From: Stuart Corbey
Sent: 20 February 2019 10:14
To: Karen Parsons
Subject: RE: 1&2 Lyon street - storage

BR/227/18/PL

PROPOSED PLAN
LYON STREET, BOGNOR REGIS, WEST SUSSEX.

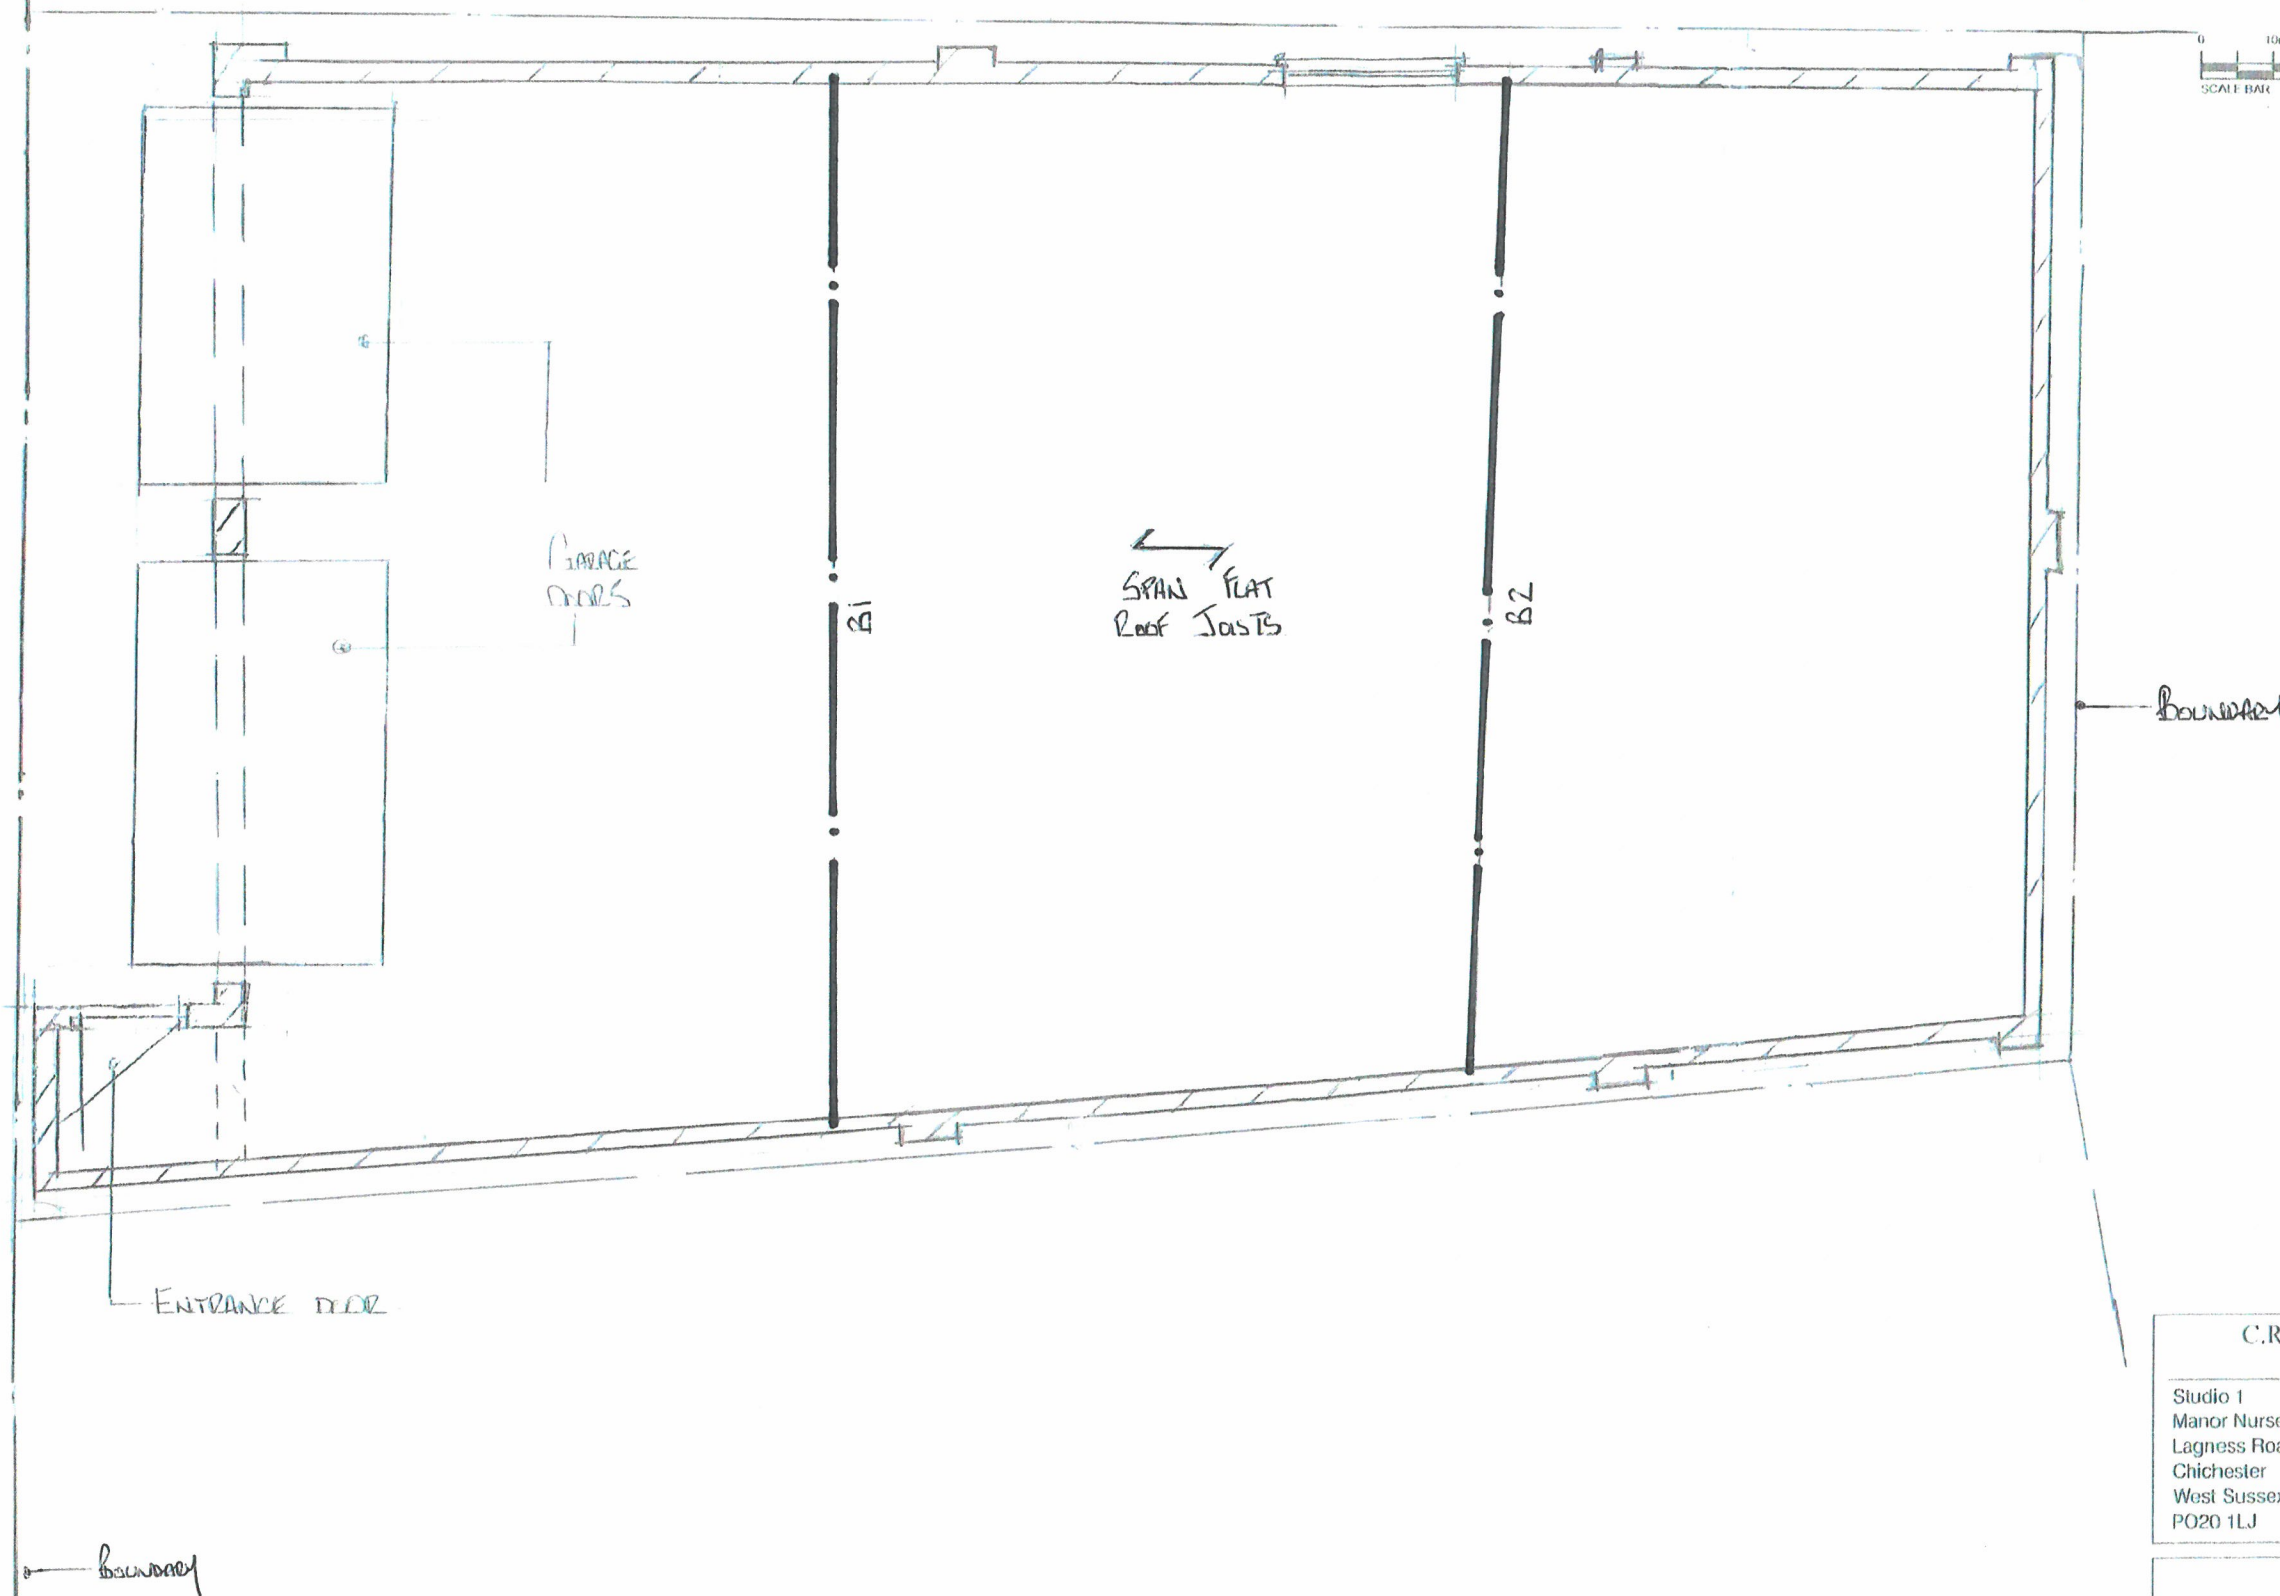
In addition to satisfy the highways concern and also as requested, we would accept additional layout plans highlighting the internal floor plan. This should indicate an area abutting the garage door for the parking of vehicles and areas dedicated to storage.
